July 7, 2011
Subject: **Portland Marine Terminal**
Federal Project No: DTMA1G10006/TIGER
State PIN: 017820.00
Amendment No. 3

Make the following changes to the Bid Documents:

5 ENTRY WALL DETAILS @ STOREFRONT
SCALE: 3" = 1'-0"

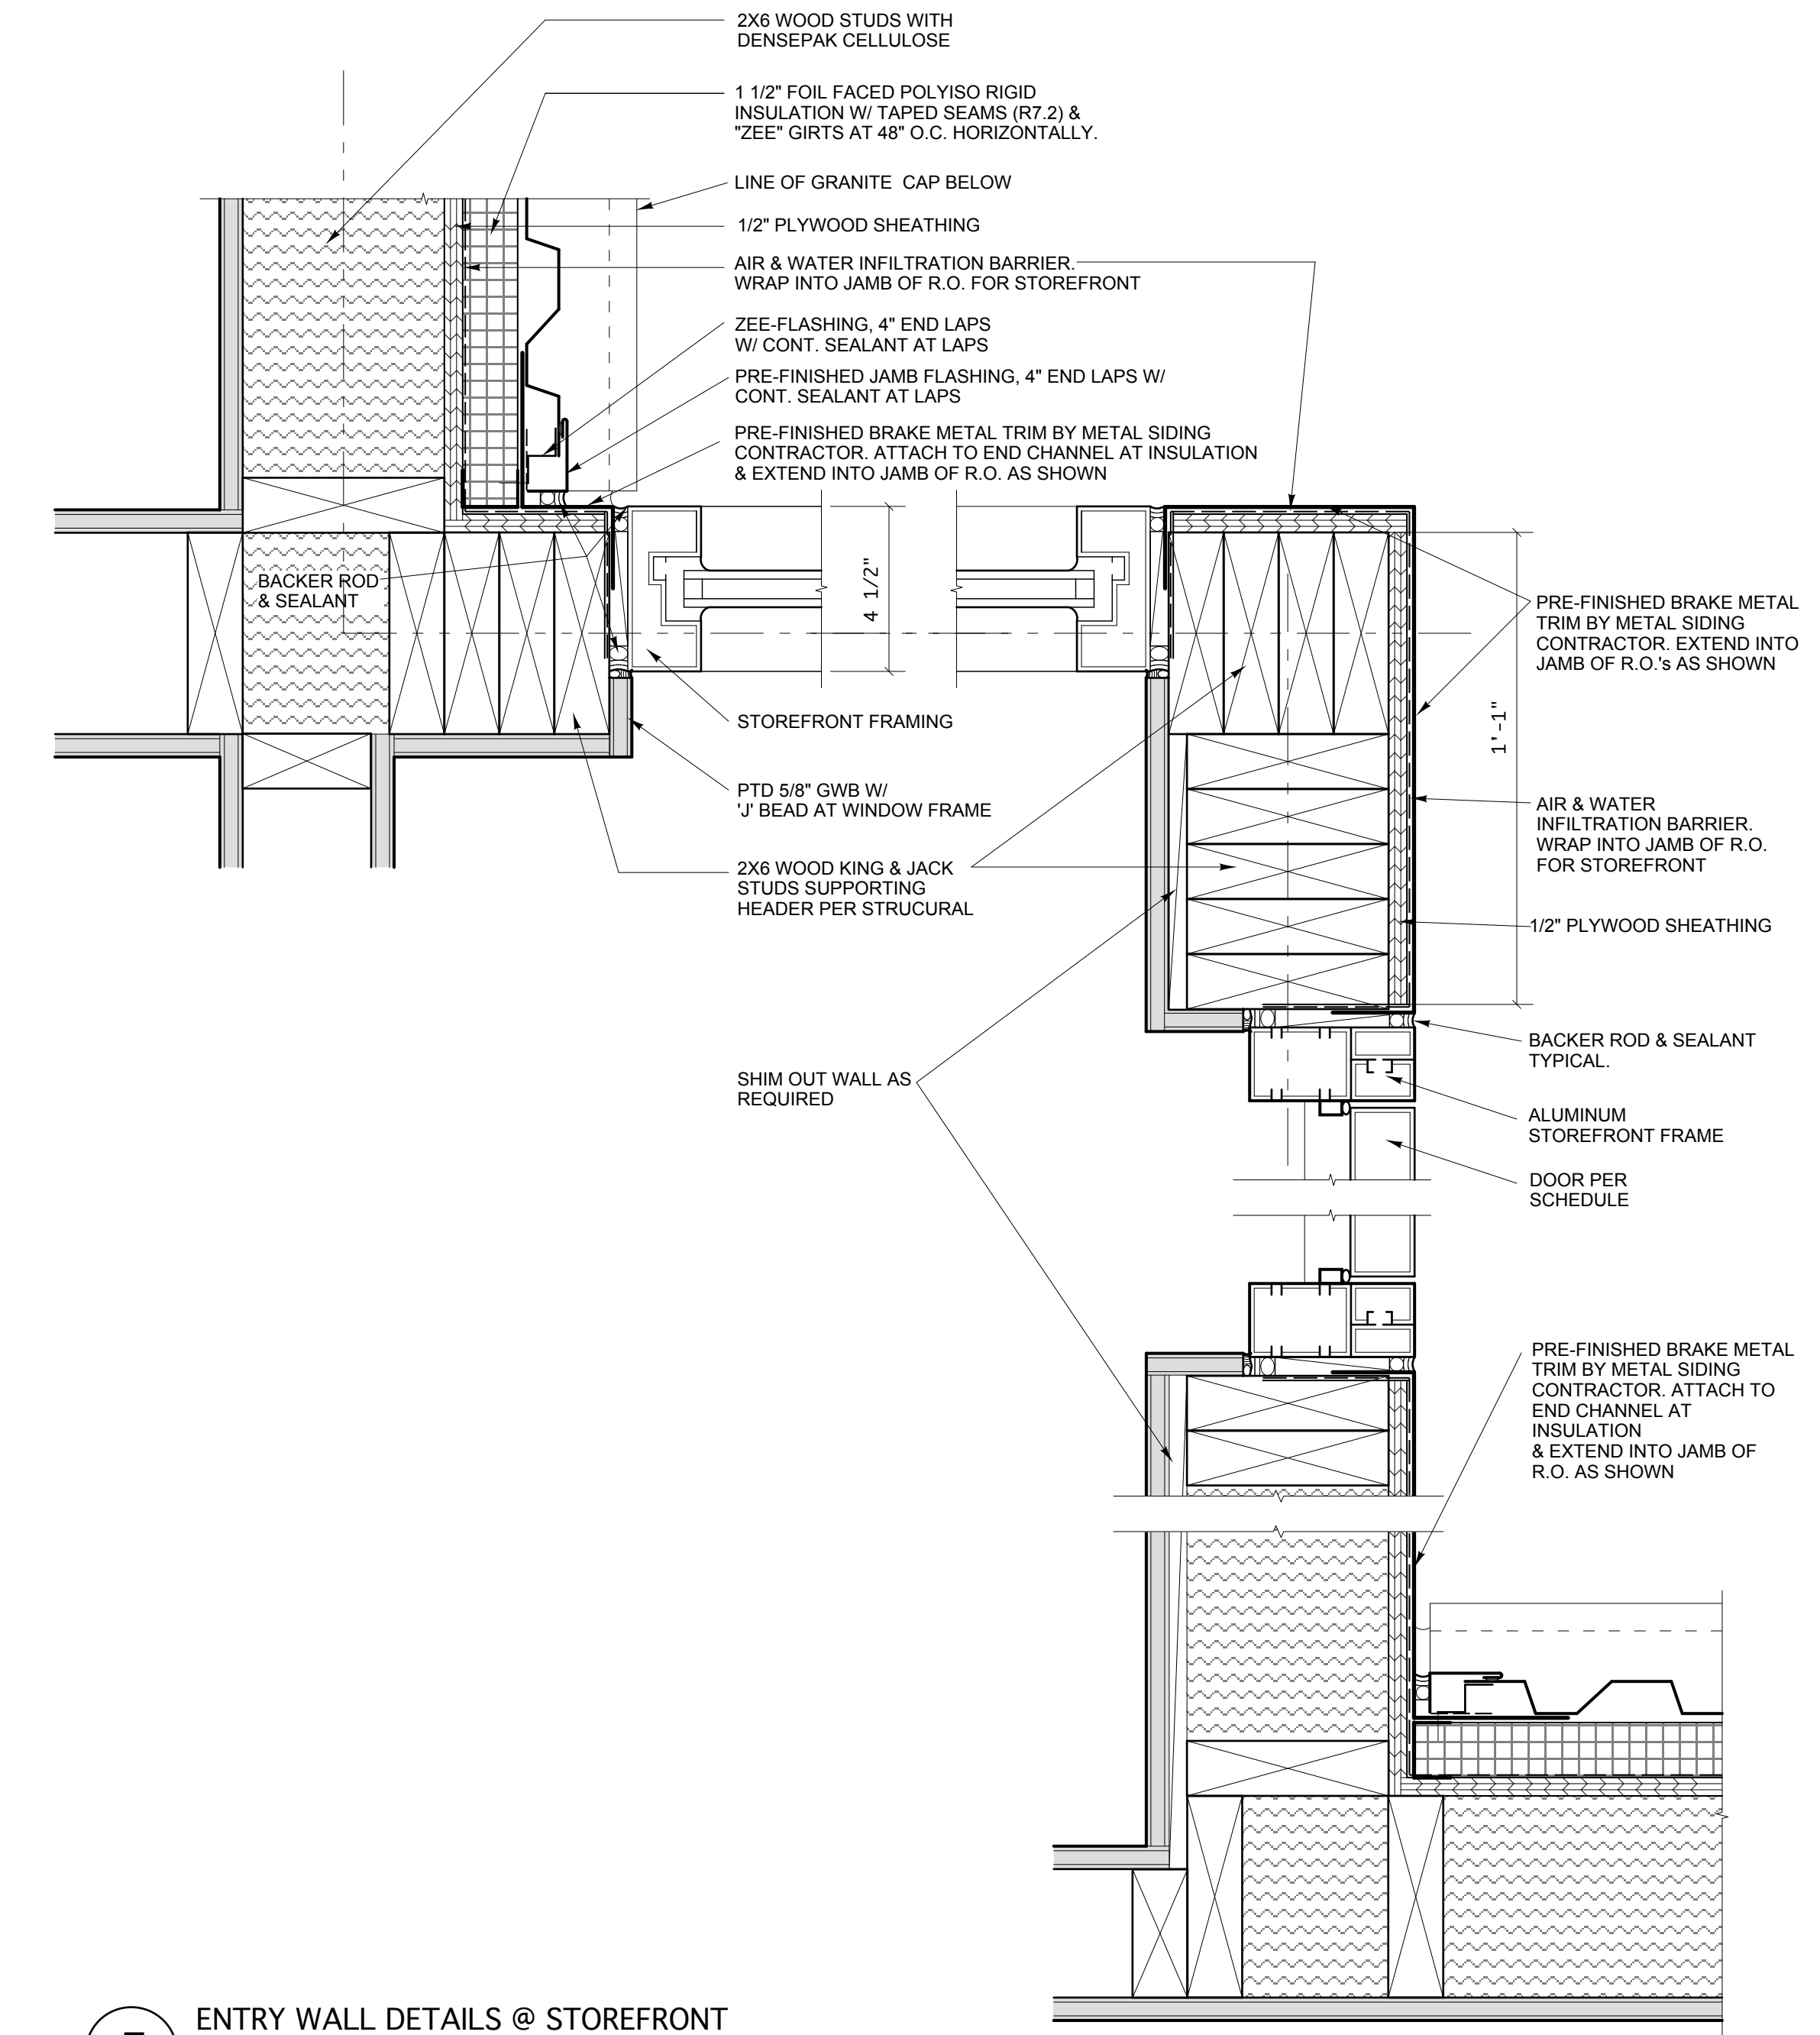
Question: Section 07 42 13 2.04 B1 calls for a Berridge FW-12 profile which is a flush profile for wall & soffit panels but the plans on details such as 1, 3, 4, & 5 on A.A6 call for an HR-16 which is corrugated for wall panels and the Vee panel for the soffit. Please clarify which profiles are required.

Response: This question was addressed in RFI #09, and is repeated here: The details are correct. The siding is to be Berridge HR-16 panels or approved equal. The soffit panels are to be Berridge Vee-Panel or approved equal.
